Norfolk County Council

Response to Deadline 2 Submissions

Norwich to Tilbury

Deadline 3 – 10 April 2026

Drawing file: published-documents / EN020027-000429-6.4.F2 Environmental Statement Figure 4.2 - Proposed Project Design - Permanent Features.pdf

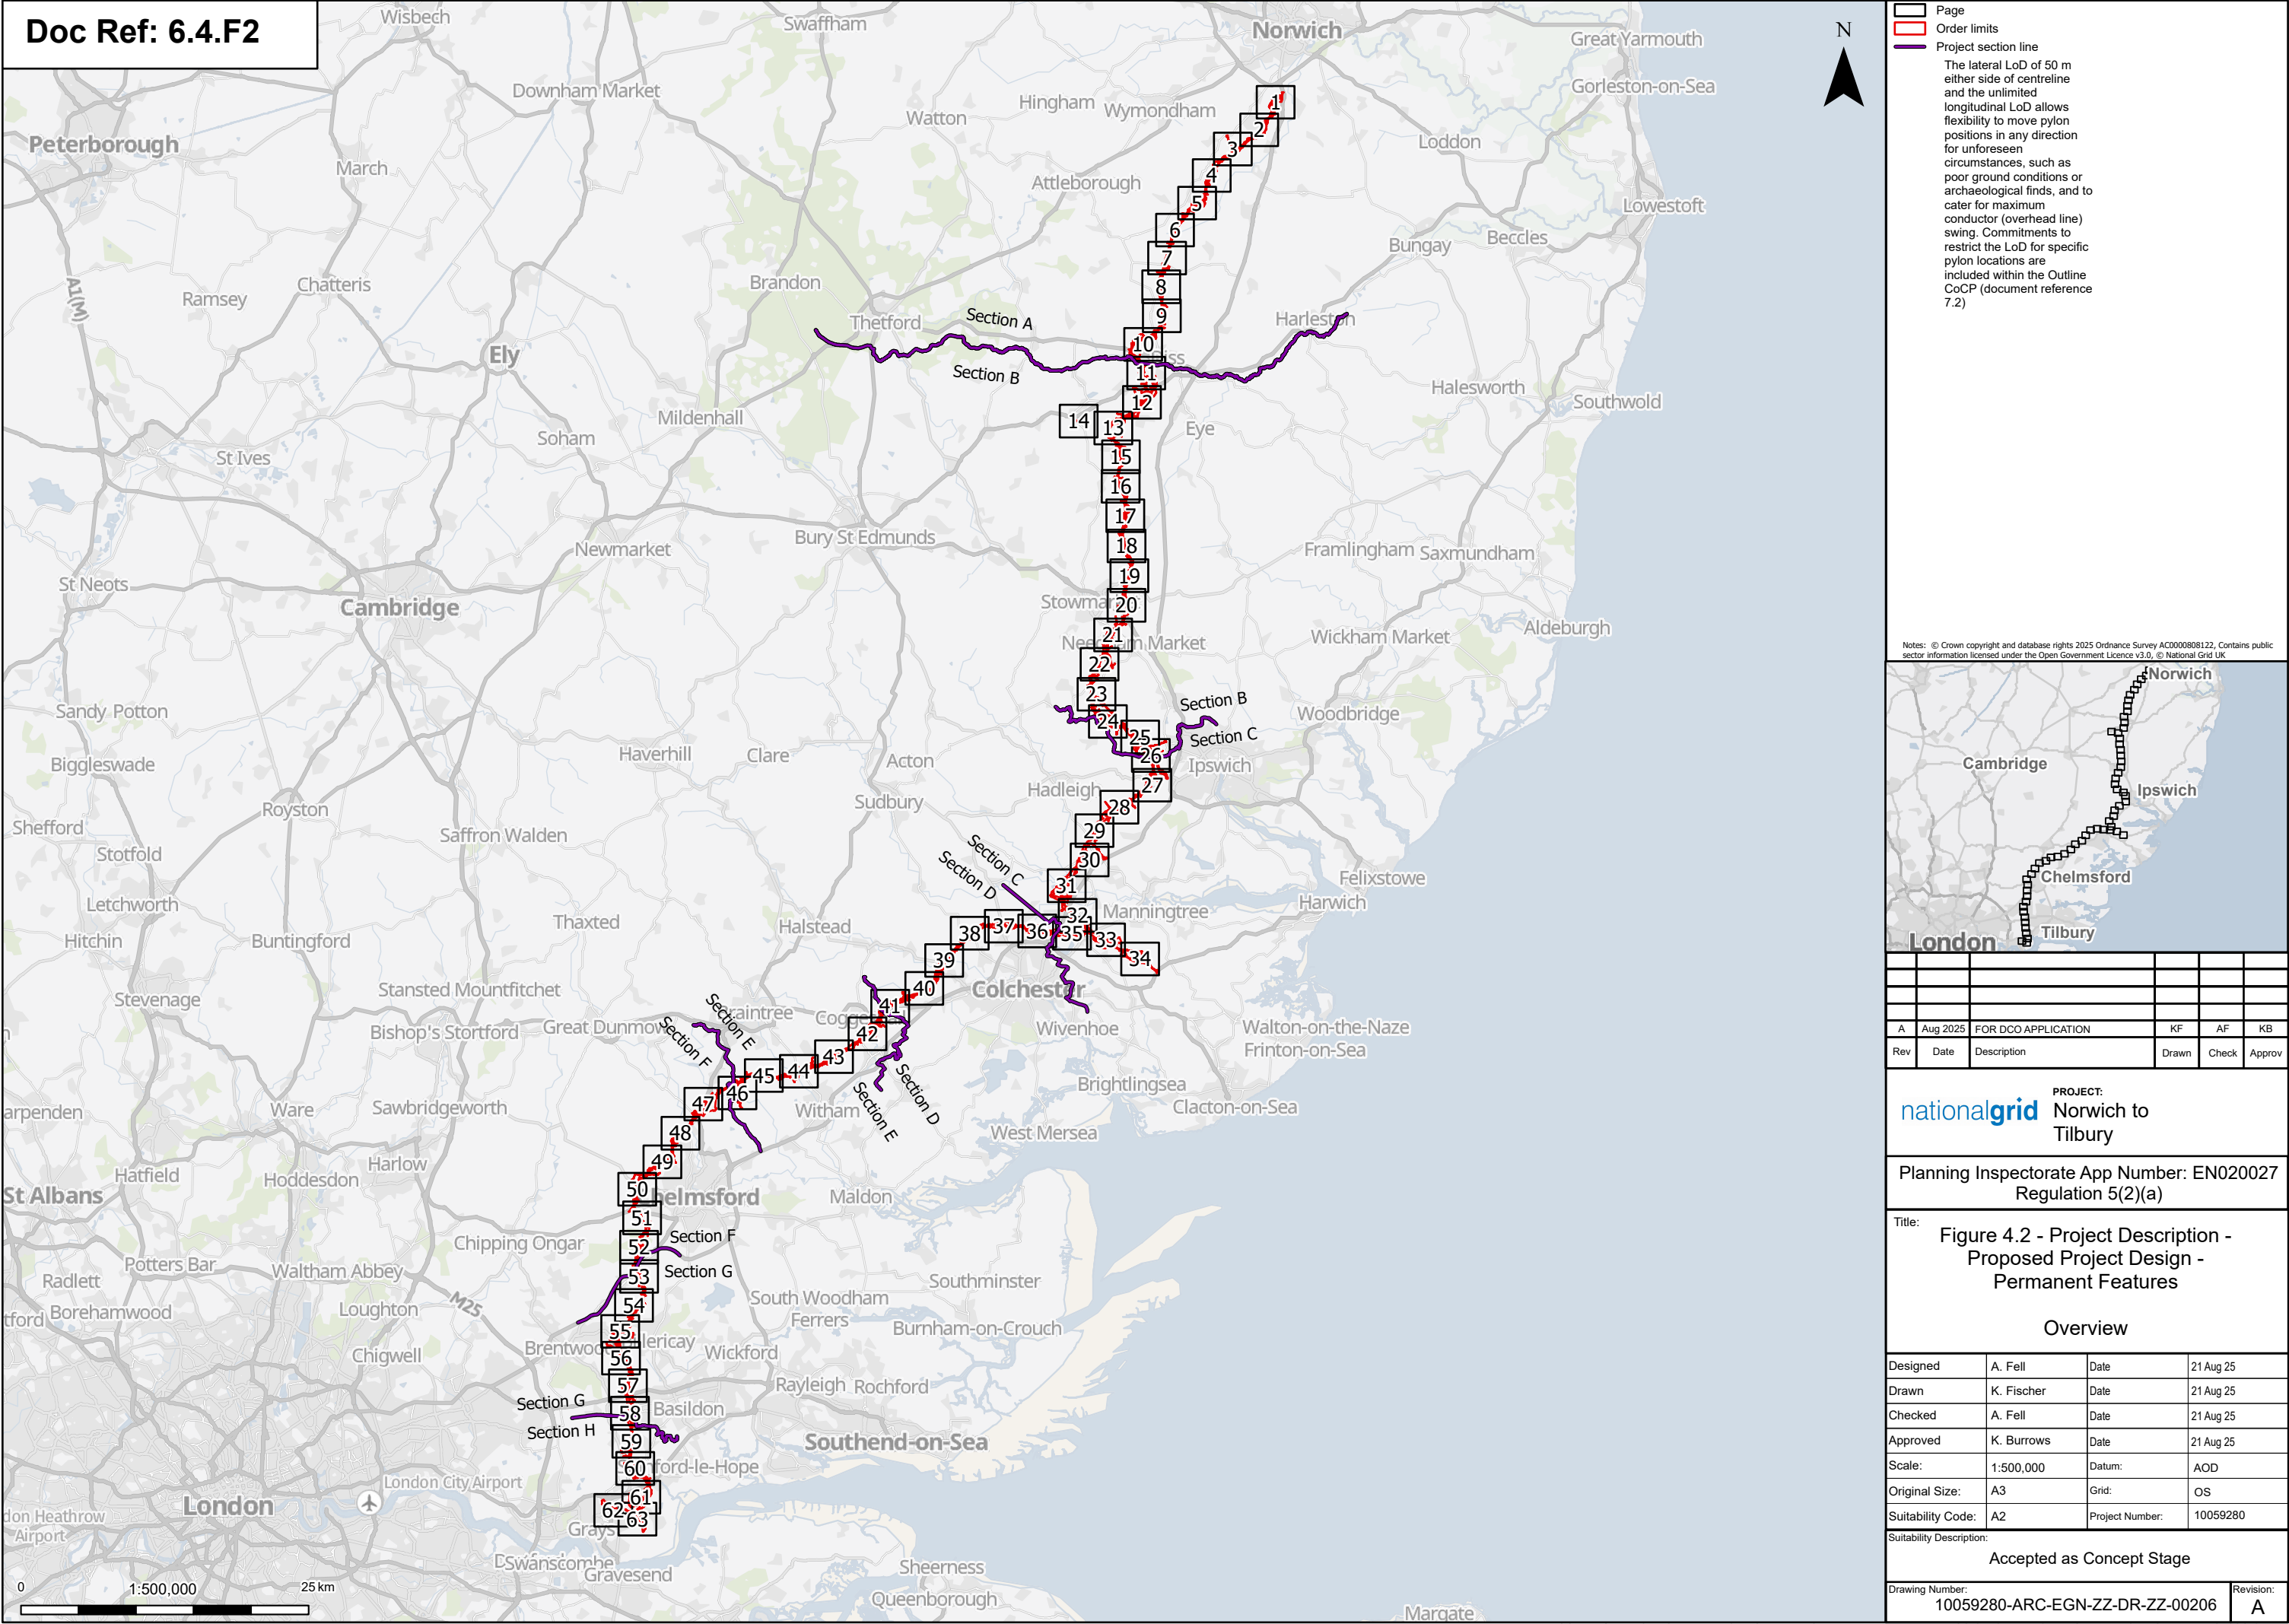
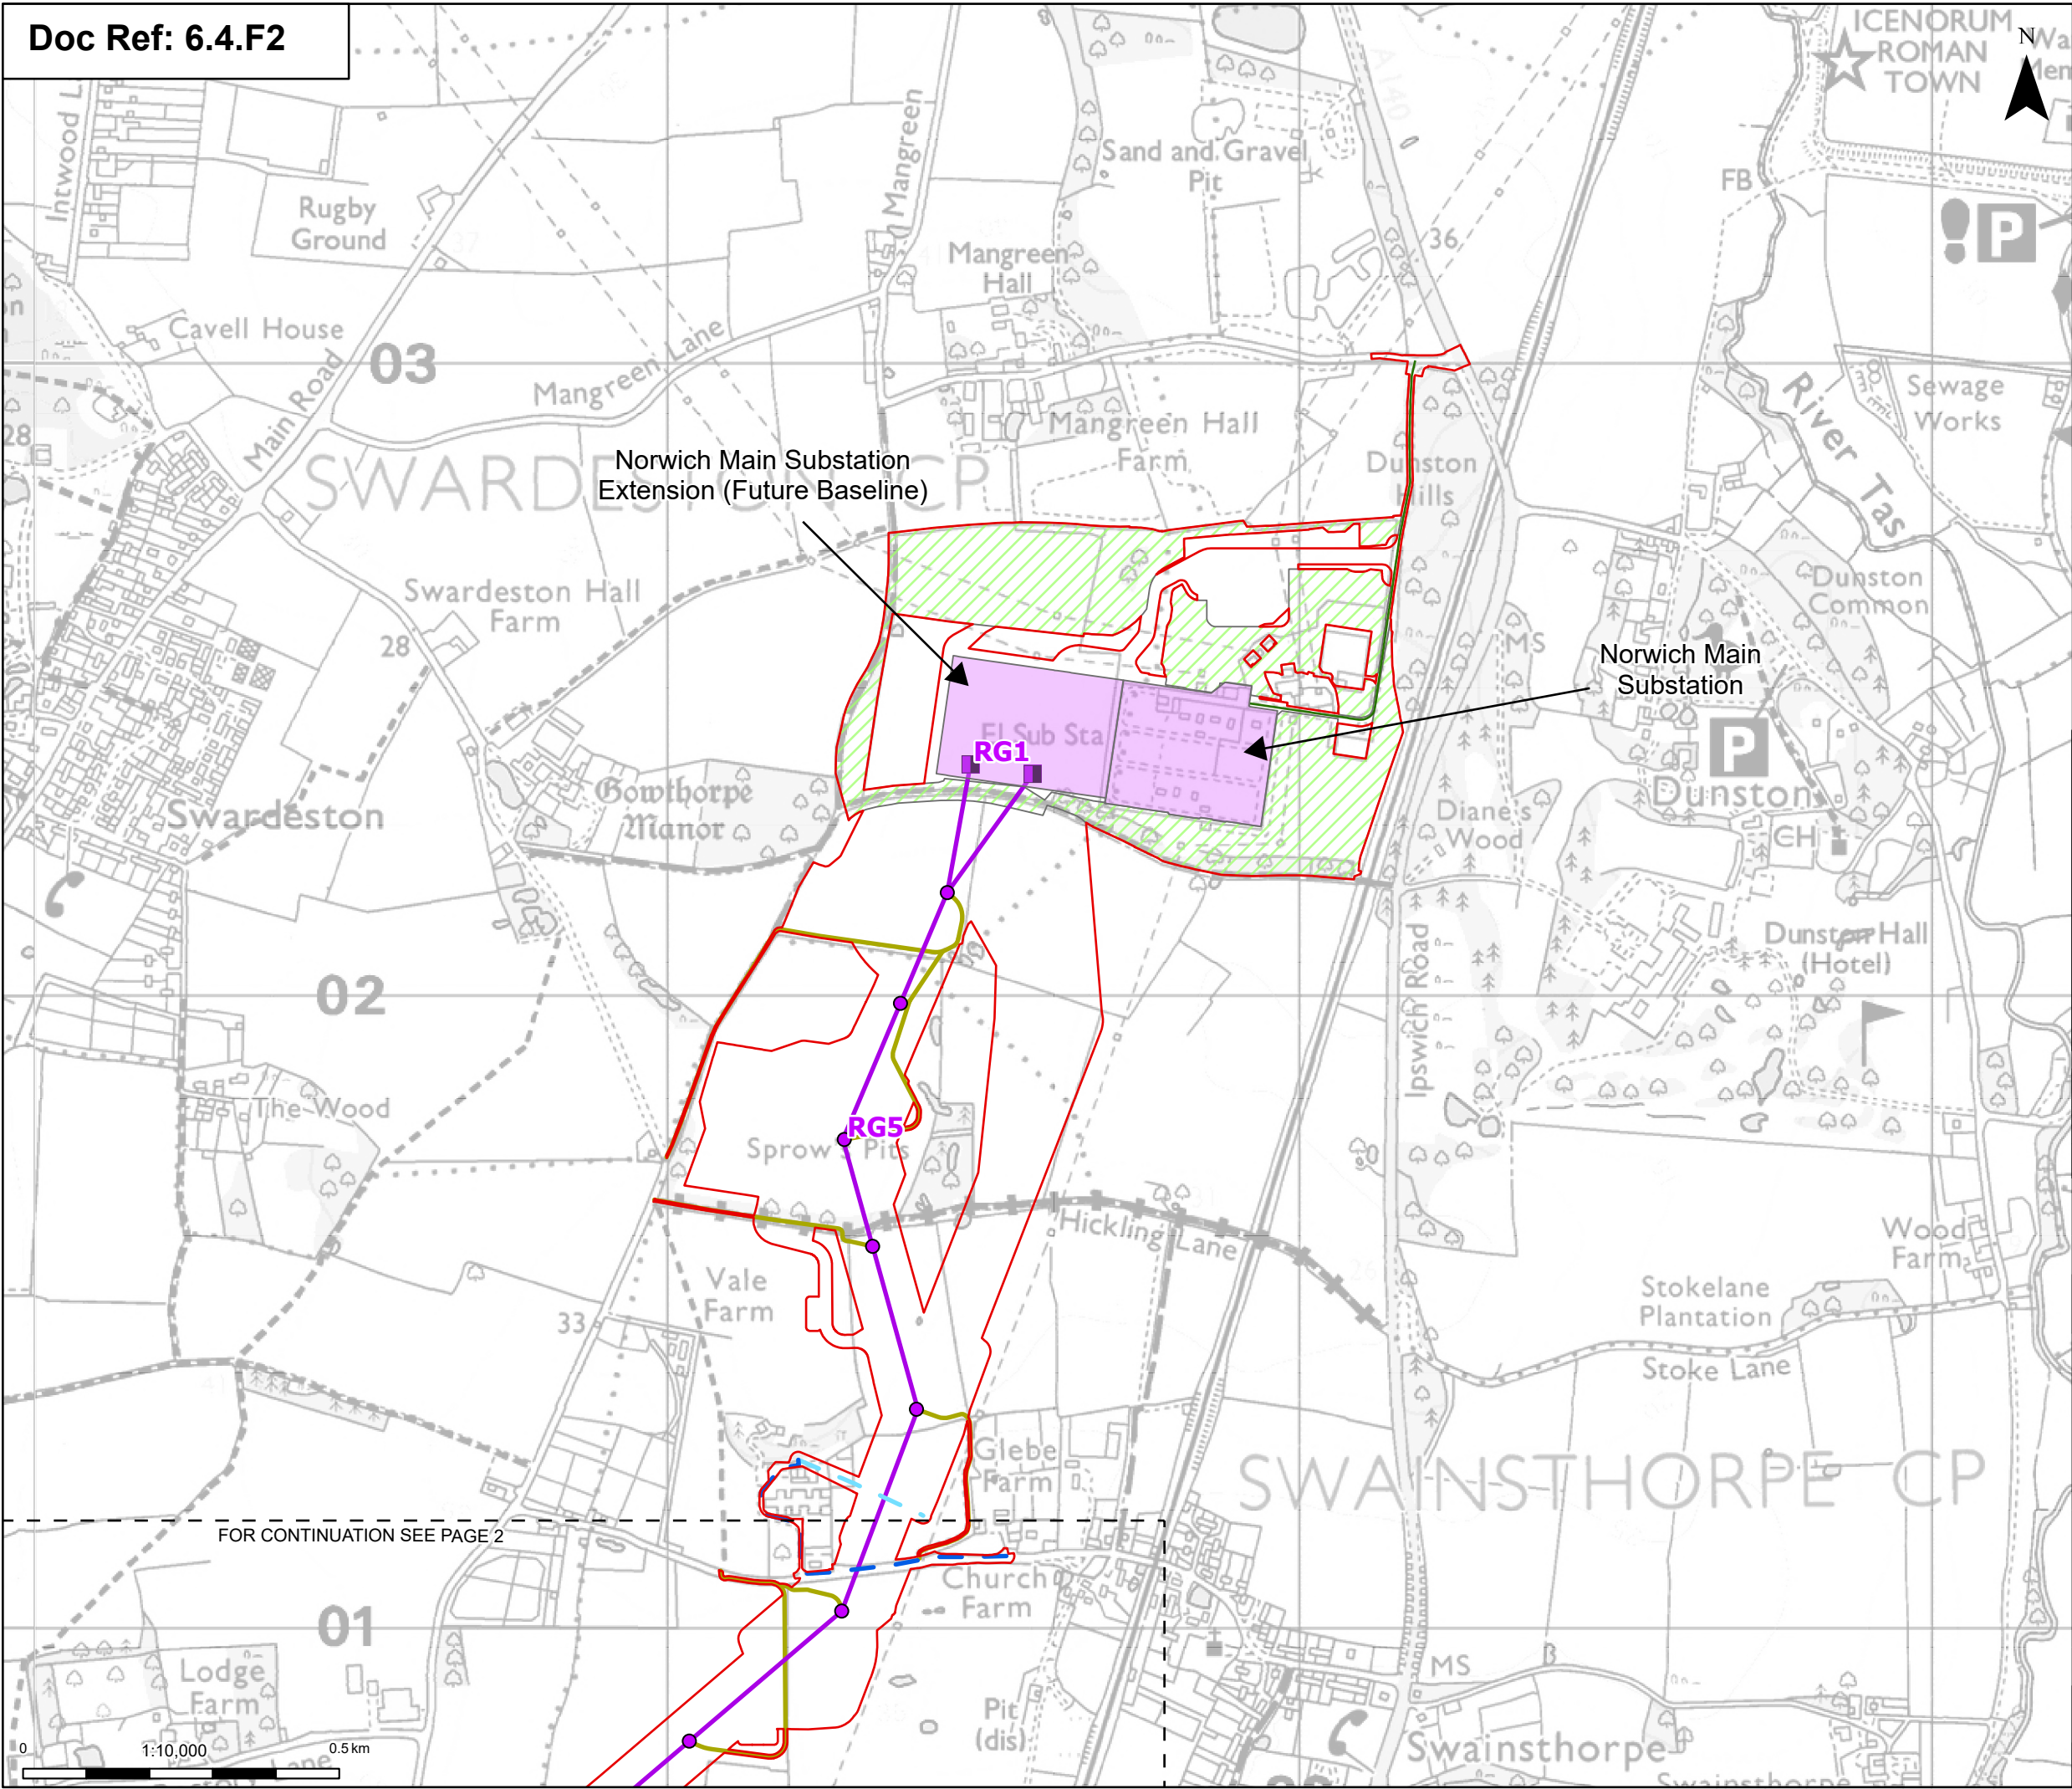
42. Again, in relation to section 5.4.2, the applicant states "The above hierarchy is a summary of the potential discharge routes which could be utilised at each site. The respective site layouts are shown in 6.4.F1 Environmental Statement Figure 4.1 - Proposed Project Design [APP-133] and 6.4.F2 Environmental Statement Figure 4.2 - Proposed Project Design -Permanent Features [APP-134] and the proposed discharge methodology per drainage pond is shown in Appendix A."

43. On review of Figure 4.1, Figure 4.2 and Appendix A, it is not possible to make a connection between the information and references provided in the drawings and the information provided in Appendix A. In Figure 4.1, the proposed overhead line construction SuDS basins are the only SuDS features with a symbol on the plans. These SuDS features are not labelled in Figure 4.1. In Appendix A, a pond reference number is provided along with a contributing catchment area. This information is not provided in either Figures 4.1 or 4.2. Furthermore, the order of the ponds appears to not be provided in a north to south approach and is therefore inconsistent with the approach taken in the previous section of the drainage strategy. In Appendix A, there are a number of statements in the "notes/assumptions/risks" section that state "Infiltration of surface water considered unsuitable. Shallow groundwater not identified." followed by a statement of "Infiltration may be deemed possible after infiltration test." This

indicates to the LLFA that at present no ground investigation has taken place. Therefore, it is not possible for the applicant to determine whether infiltration is viable. The LLFA Developer Guidance is clear that where in the early stages of design that infiltration testing has not been undertaken, the developer should assume that infiltration is possible as a Plan A approach while demonstrating that a viable Plan B is available. At present, the applicant has not been able to demonstrate that either a Plan A or a Plan B could be viable due to a lack of information. It is also not possible to check or confirm the whether the proposed discreet drainage catchment area is appropriate and therefore, that appropriate sizing of the attenuation basin has occurred. **Further work and information is required.**
